KITTITAS COUNTY COMMUNITY DEVELOPMENT SERVICES

DATE: October 5, 2022

SUBJECT: Pre-Application Meeting PM-22-00015, CDS Building Notes.

**SITE PLAN 11x17
EVENT USE**

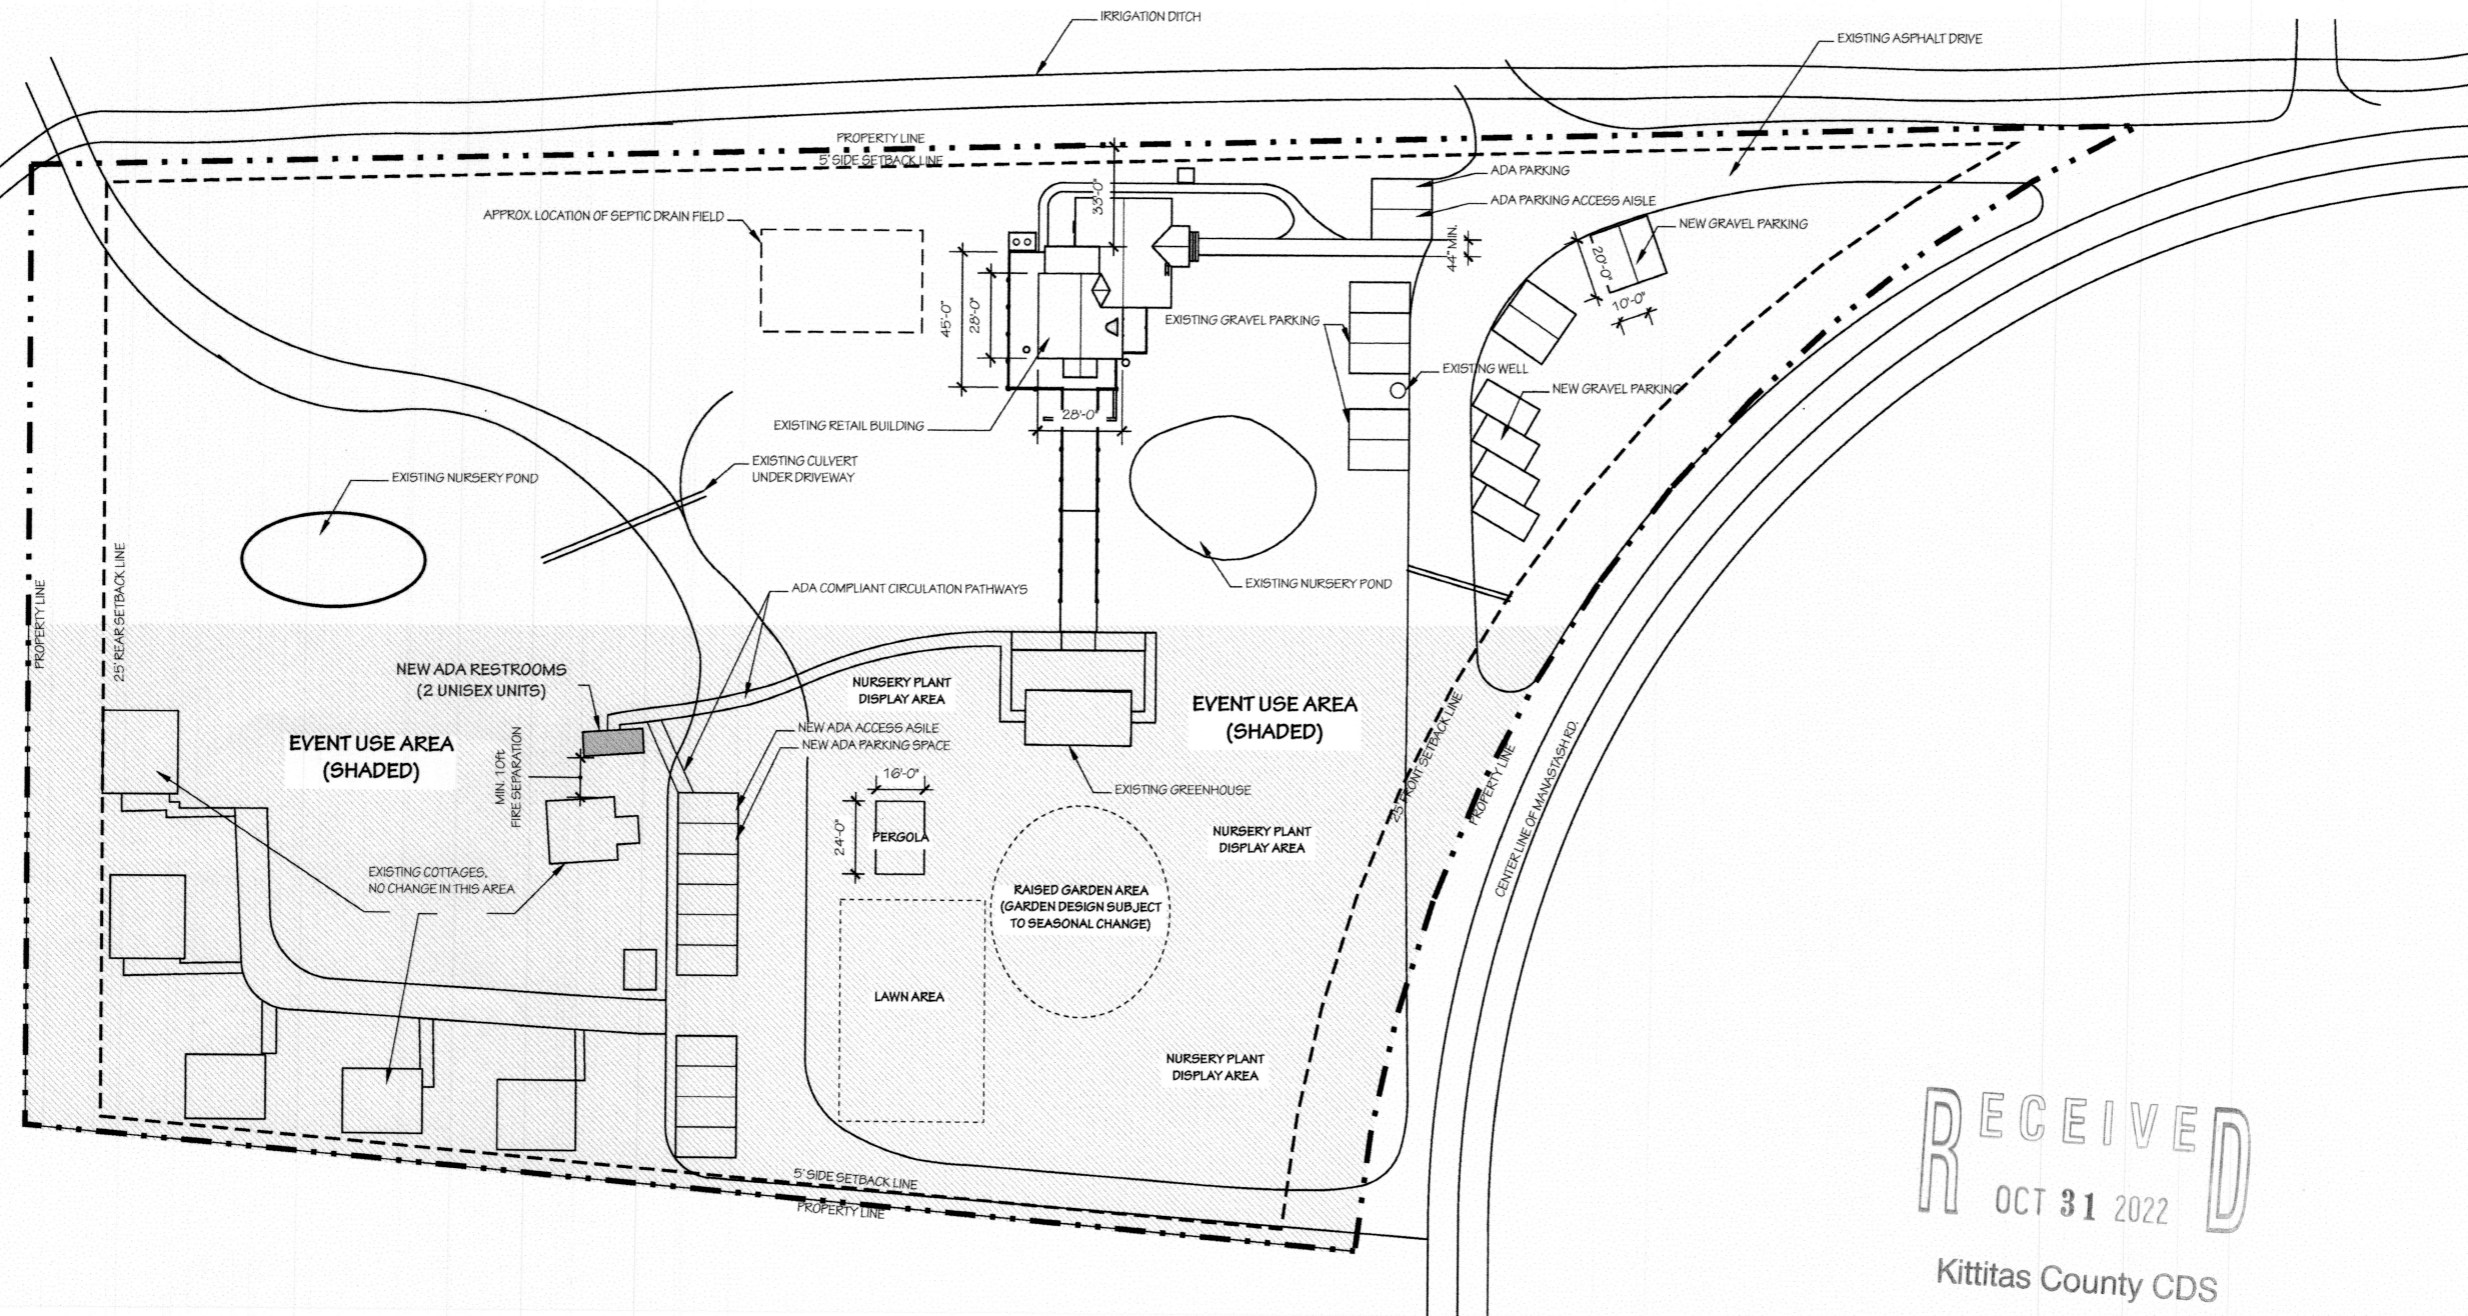
- b. The proposed restroom building will need to be made accessible.
- c. Accessible parking and route to Accessible space(s) provided with hard surface such as asphalt or concrete. The parking symbol and signage of Accessibility is required. Accessible parking spaces shall be located on the shortest accessible route of travel from adjacent parking to an accessible building/ pedestrian entrance per WAC 51-50-1106. Wherever practical, the accessible route shall not cross lanes of vehicular traffic. Where crossing traffic lanes as necessary, the route shall be designated and marked as a crosswalk.

- d. Verify there is no more than 1:20 slope for the Accessible path from Accessible Parking to the building(s) and all facilities entrances and amenities. Please show path and state the maximum allowed slope on the drawings.
